From: Doug Elish [REDACTED]
Sent: 15 November 2019 14:43
To: Planning Comments
Subject: Application: 19/05000/HYB

The Sevenoaks Bicycle Users Group promotes active travel in the Sevenoaks District area.

PROPOSED STAR HILL ROAD JUNCTION

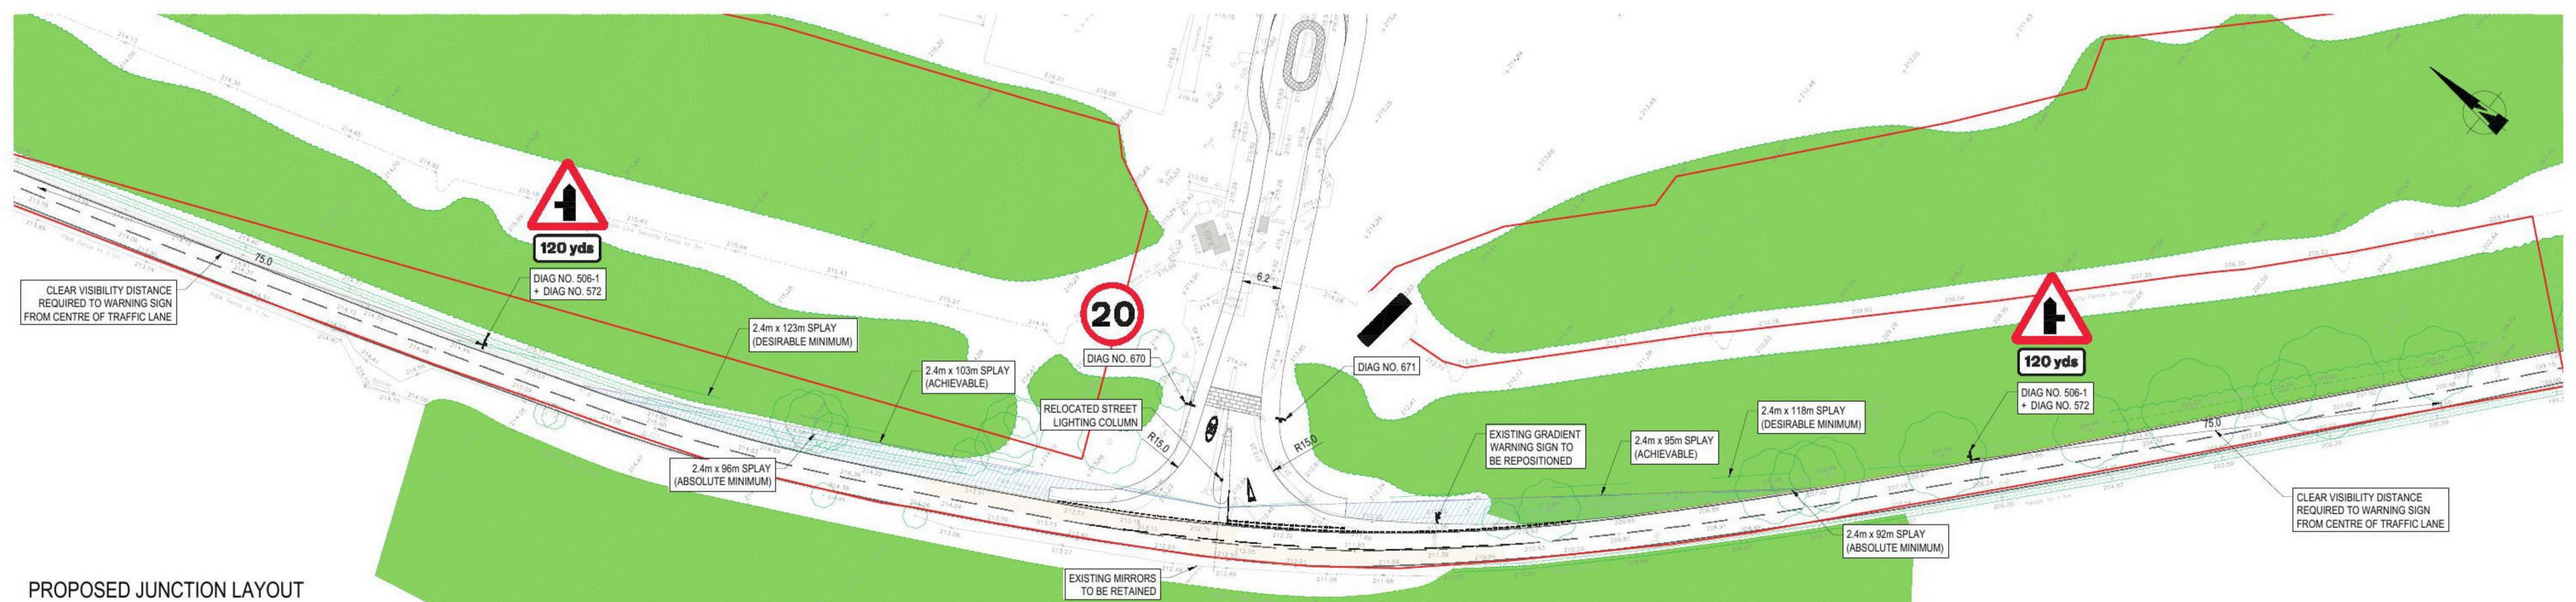
- * Another "strategic shared footway cycle path" to the south, connecting to the lower part of Starhill Road - to facilitate access to Dunton Green Station.
- * Extending the on-highway cycle lanes on London Rd (A224) between the Shoreham Lane roundabout and the Polhill access junction (to be upgraded).
- * Upgrading appropriate PROW to be both foot and cycle paths and to integrate with relevant other roads/foot & cycle paths to promote active travel.
